TR010064: Application by National Highways for the M60/M62/M66 Simister Island Interchange Project

The Examining Authority's Written Questions and requests for further information

Issued on 22 October 2024

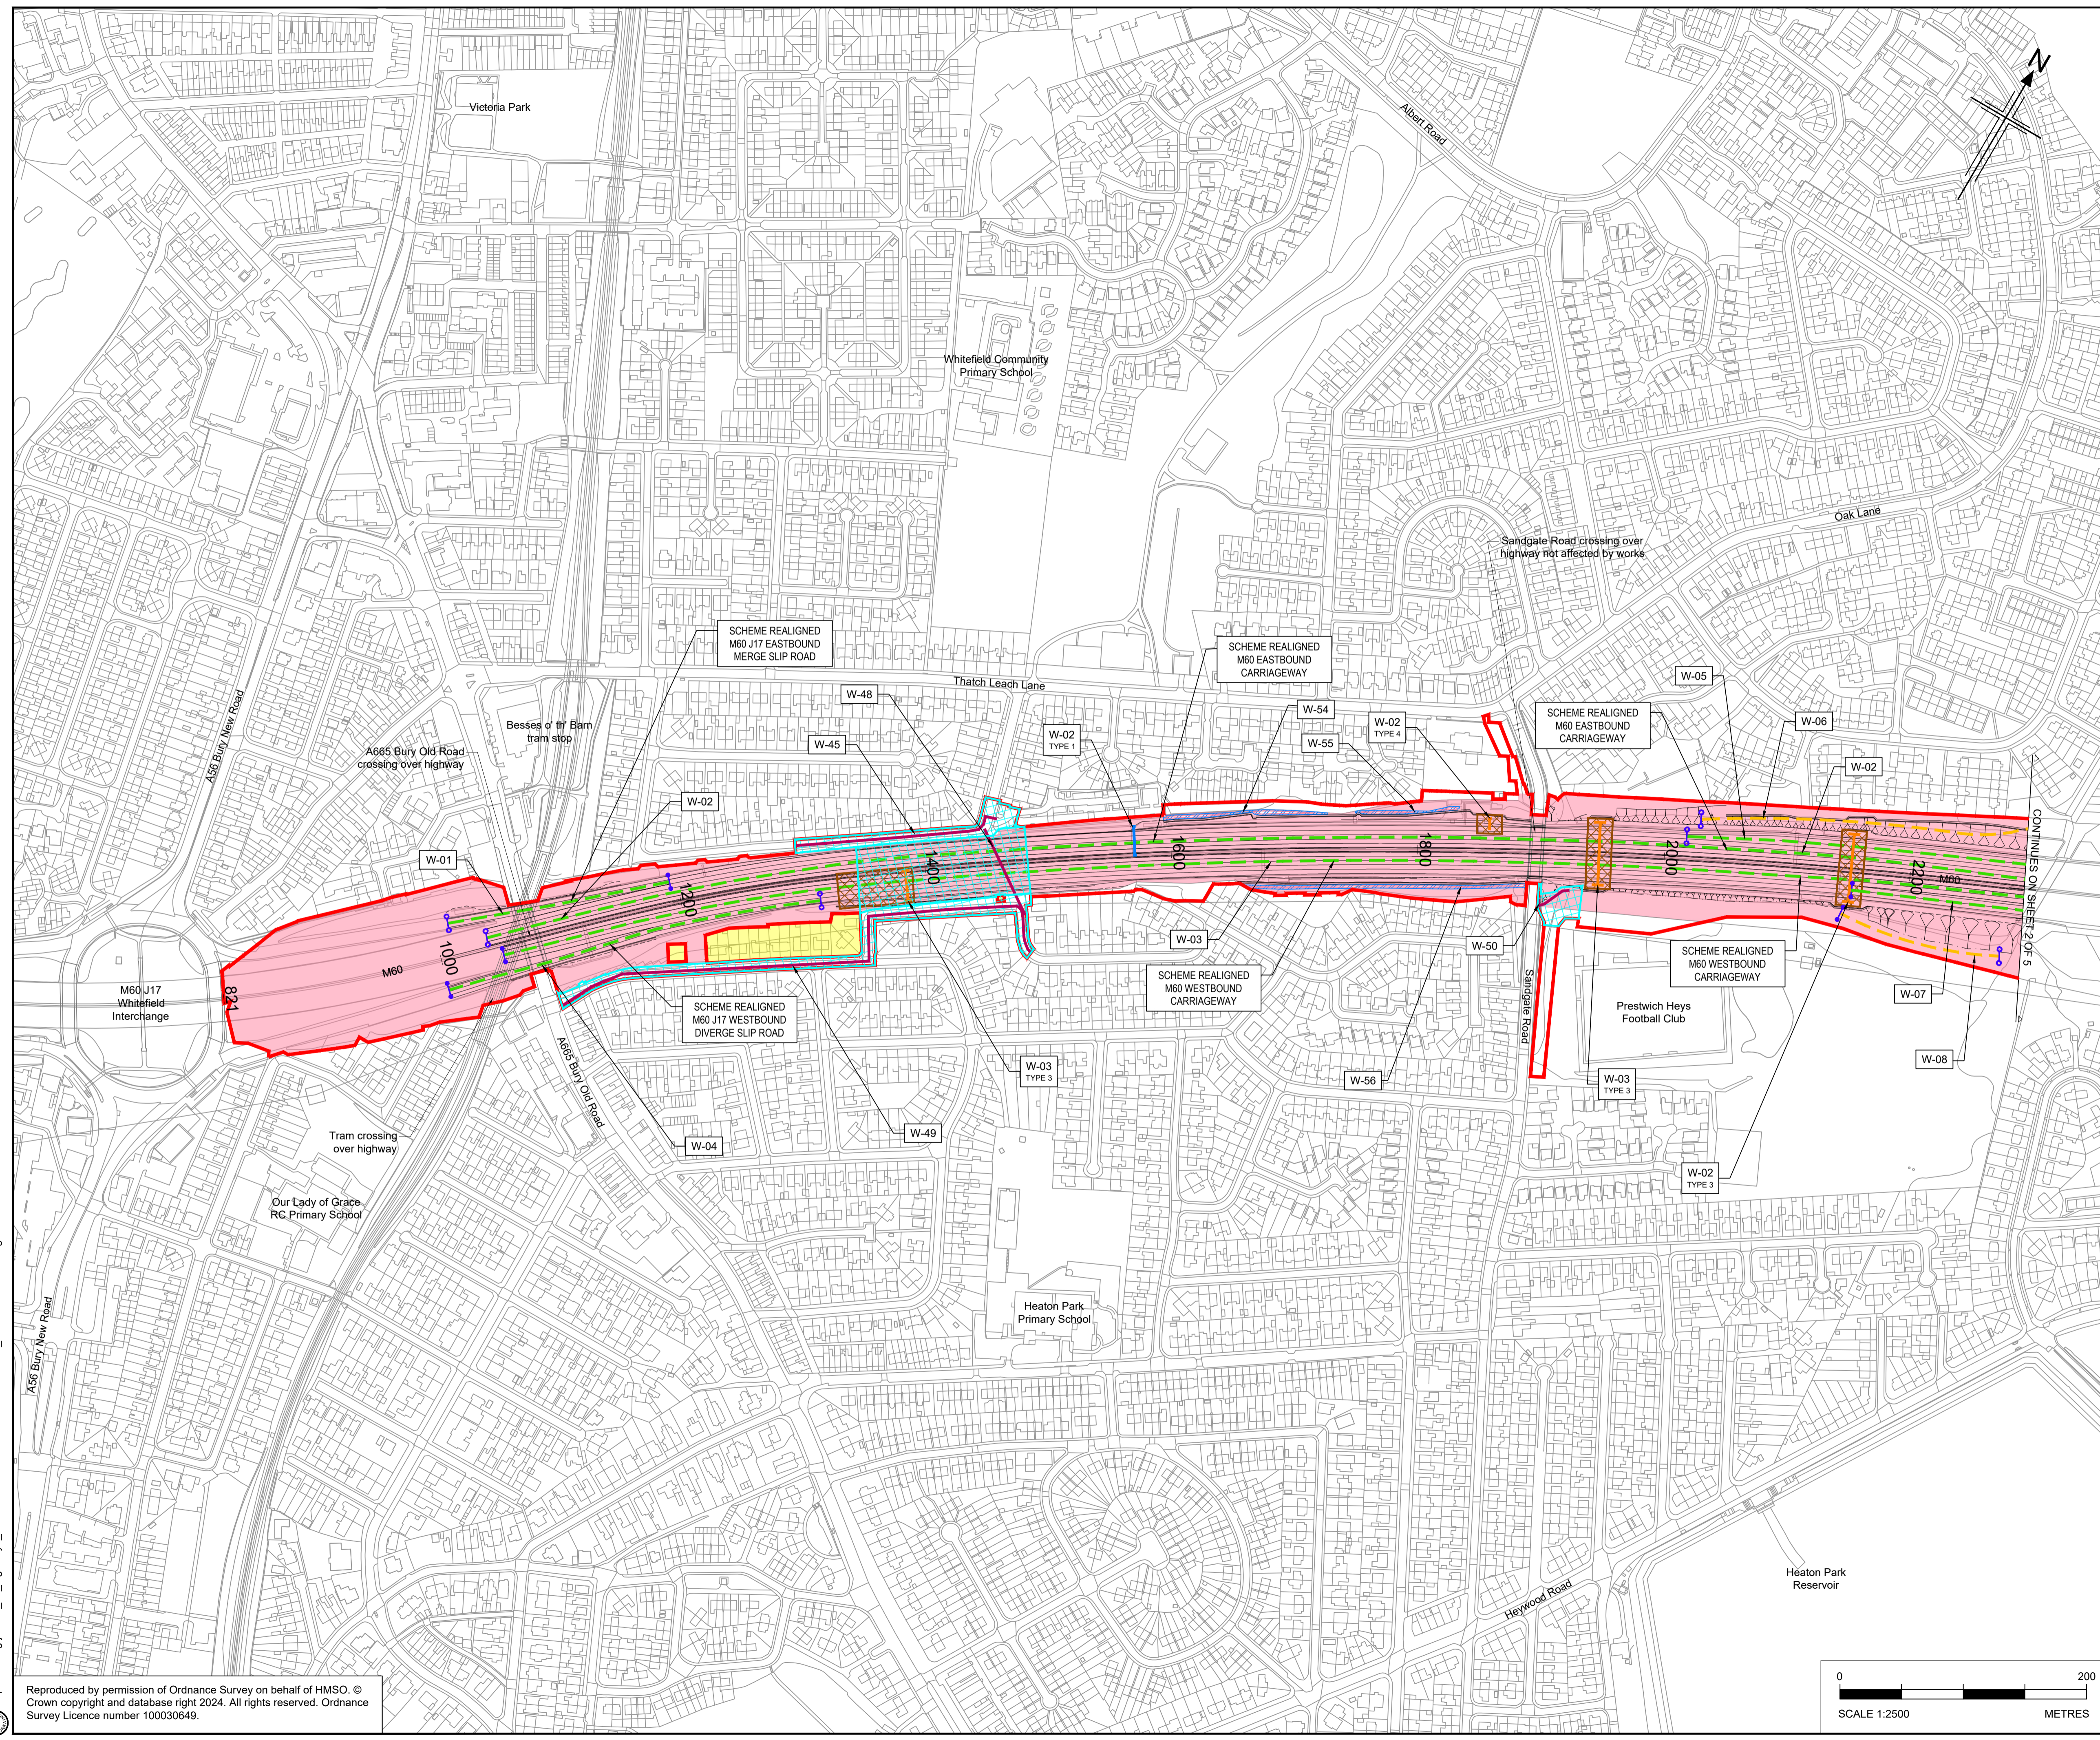
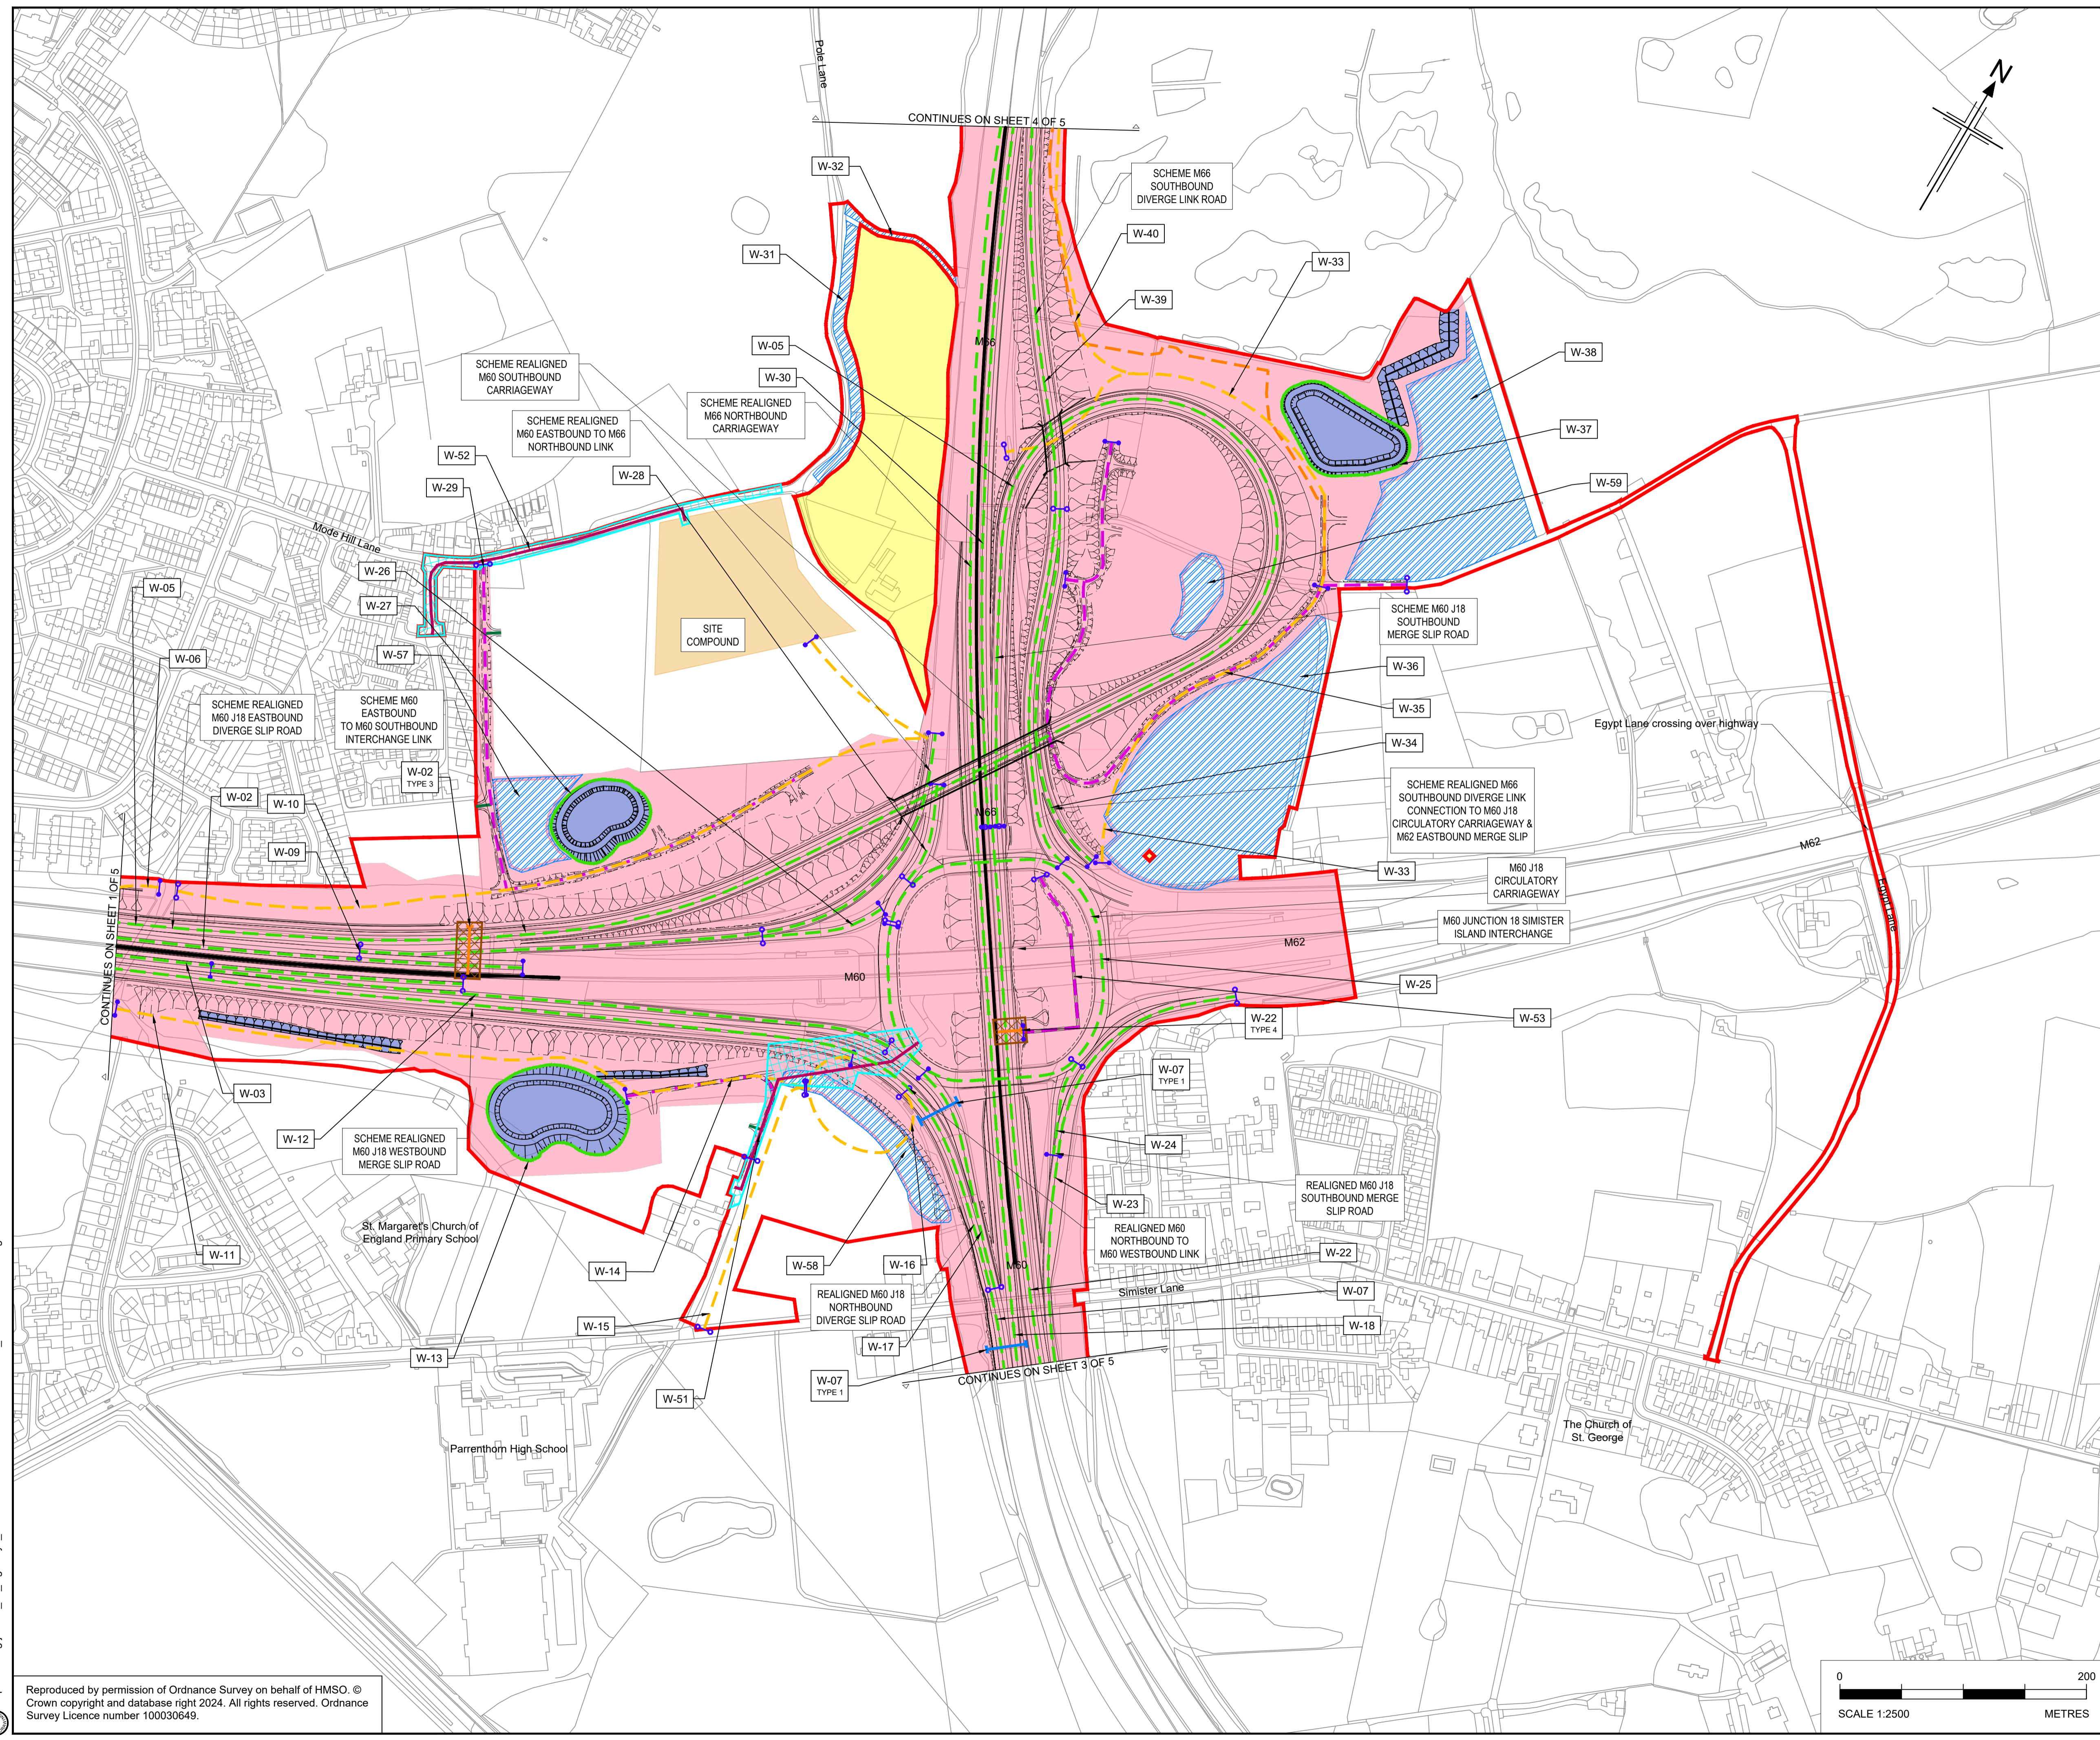
ExQ1	Question to:	Question
CA.1.9	Applicant	<p>Works Plans</p> <p>The Works Plans [AS-006] contain areas of white land, which are unexplained in the legend. The ExA consider Works Plans should be fully explanatory and indicate all land and its intended works. Amend the Works Plans, and fully annotate each area of land with a Work No.</p>
CA.1.10	Applicant	<p>Land Plans</p> <p>The Applicant's response in [REP2-007] to D1 submission [REP1-033] states "<i>The Applicant confirms that, in respect of plot 1/33b, no temporary land take is required, and the Applicant is seeking permanent Rights for access in connection with future maintenance of the Scheme only</i>". The Land Plans [AS-005] shows plot 1/33b as blue which is described as "<i>Land to be used temporarily and Rights to be acquired permanently</i>". Are there any other plots, which are shown as blue, where it is not intended that they will be used temporarily and only Rights are sought to be acquired? Consider how the plots could be coloured on the Land Plans to clarify where only Rights over land are being sought and provide revised Land Plans accordingly.</p>
